**CITY OF ALBUQUERQUE
PLANNING DEPARTMENT
June 1, 2011
DRB Comments**

PROJECT # 1002633

APPLICATION # 11-70146

RE: Lot 1-A, Ventura Place

DISCLOSURE STATEMENT:
THE PURPOSE OF THIS PLAT IS TO PLAT ONE LOT INTO TWO AND GRANT ANY EASEMENTS AS SHOWN.

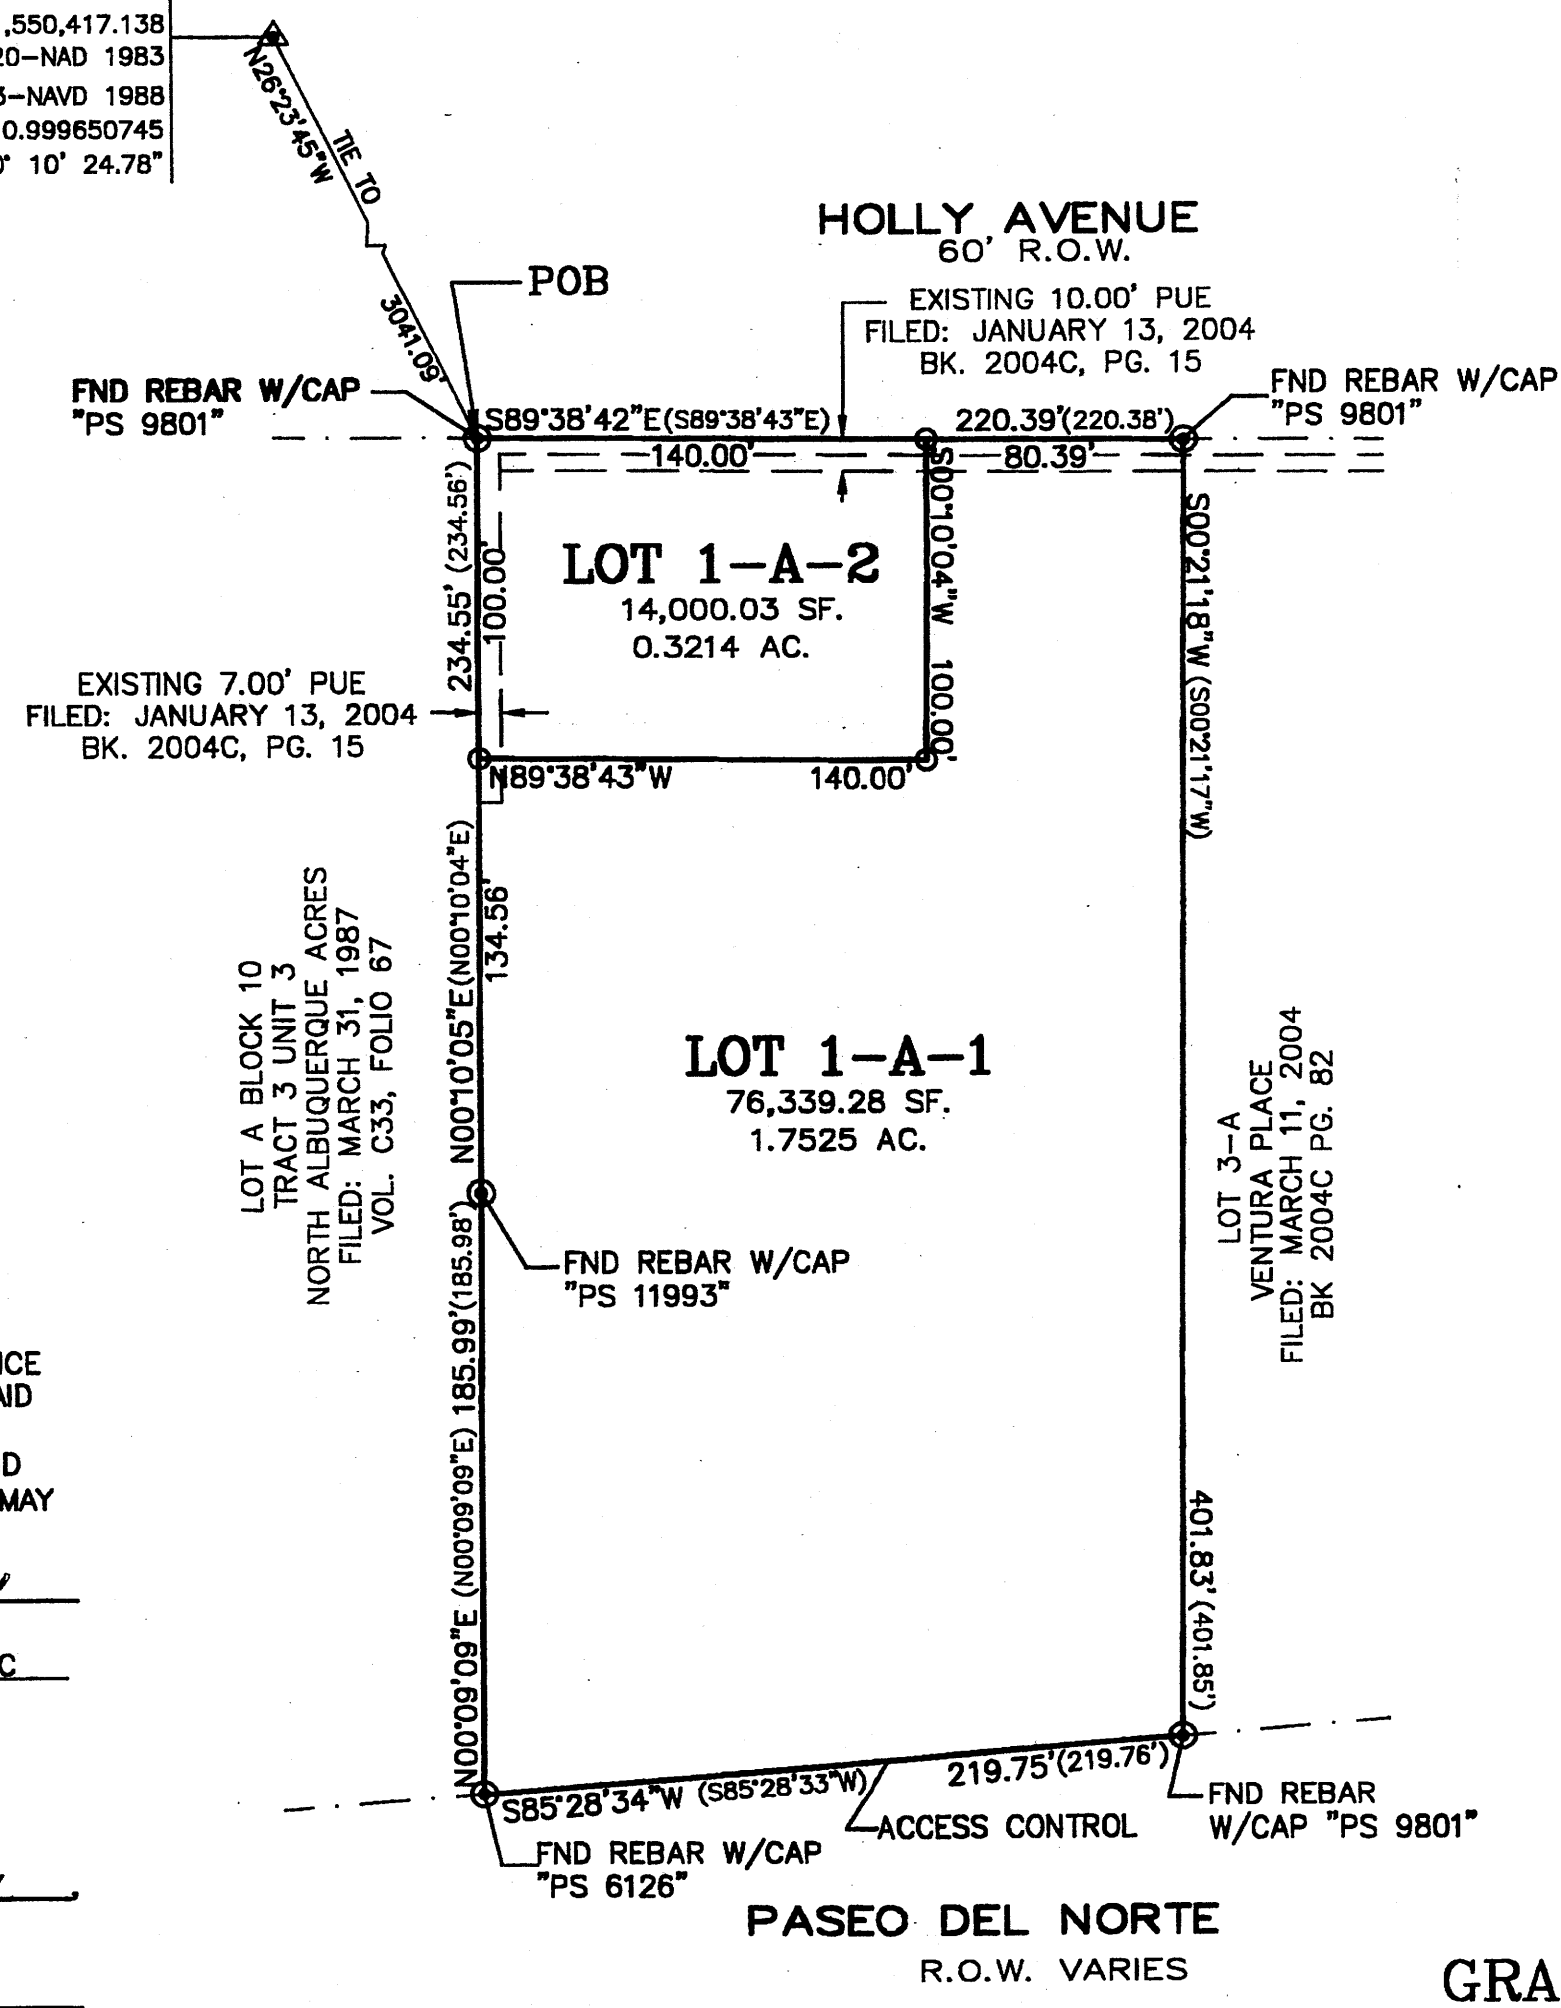
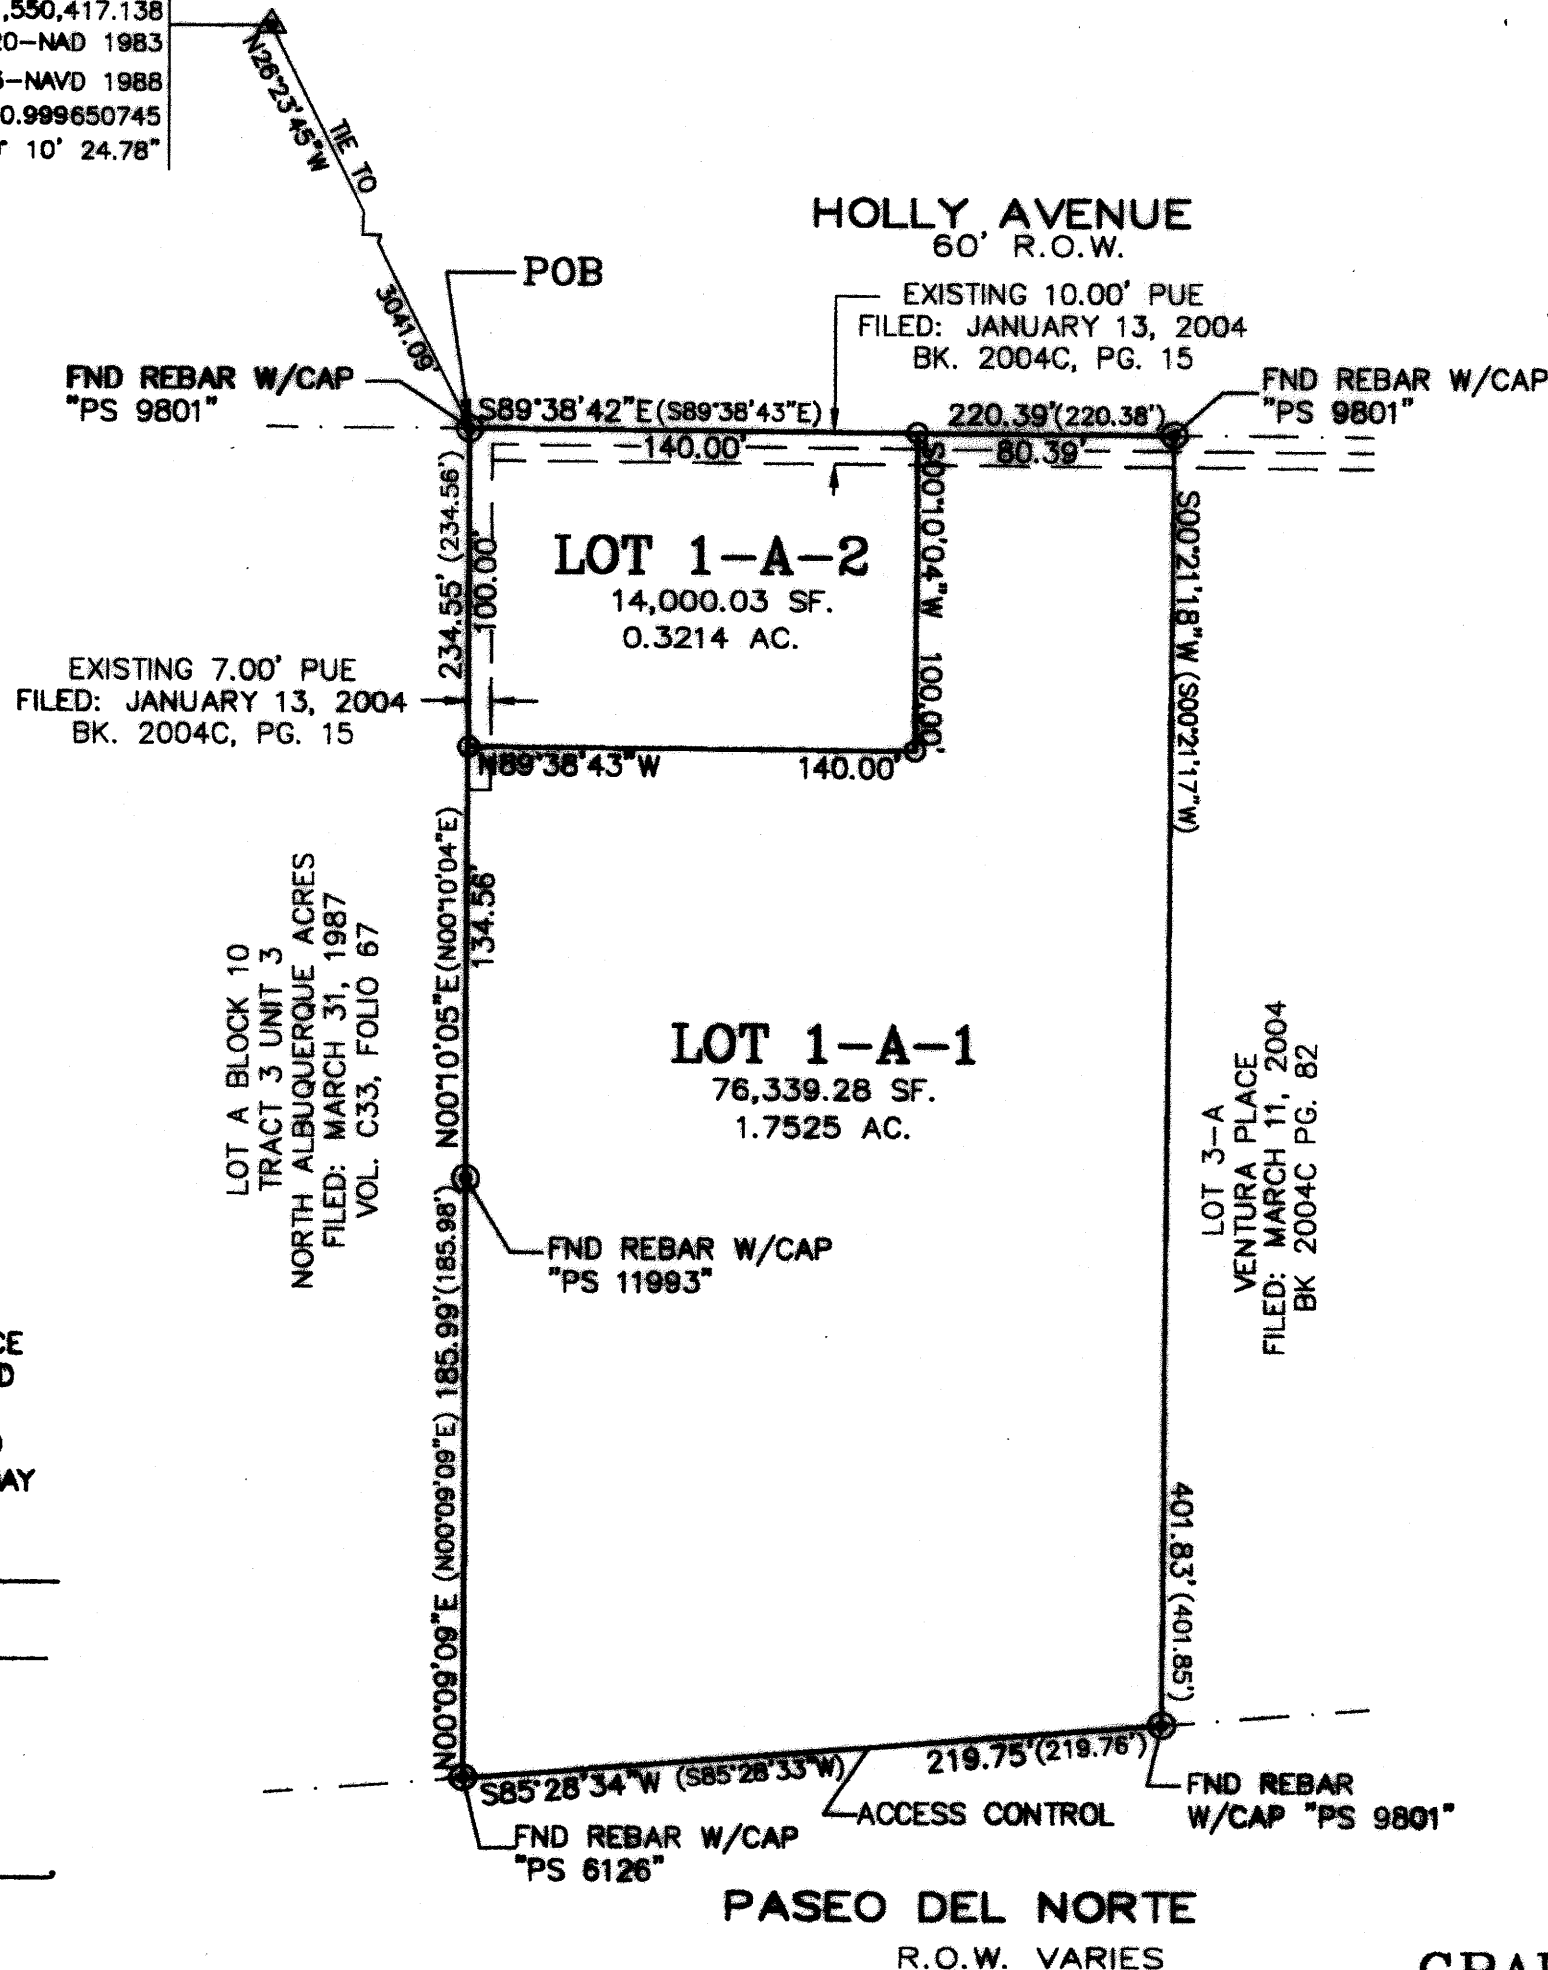
Please provide a copy of the plat referenced in Note 8 for this file to verify easements.
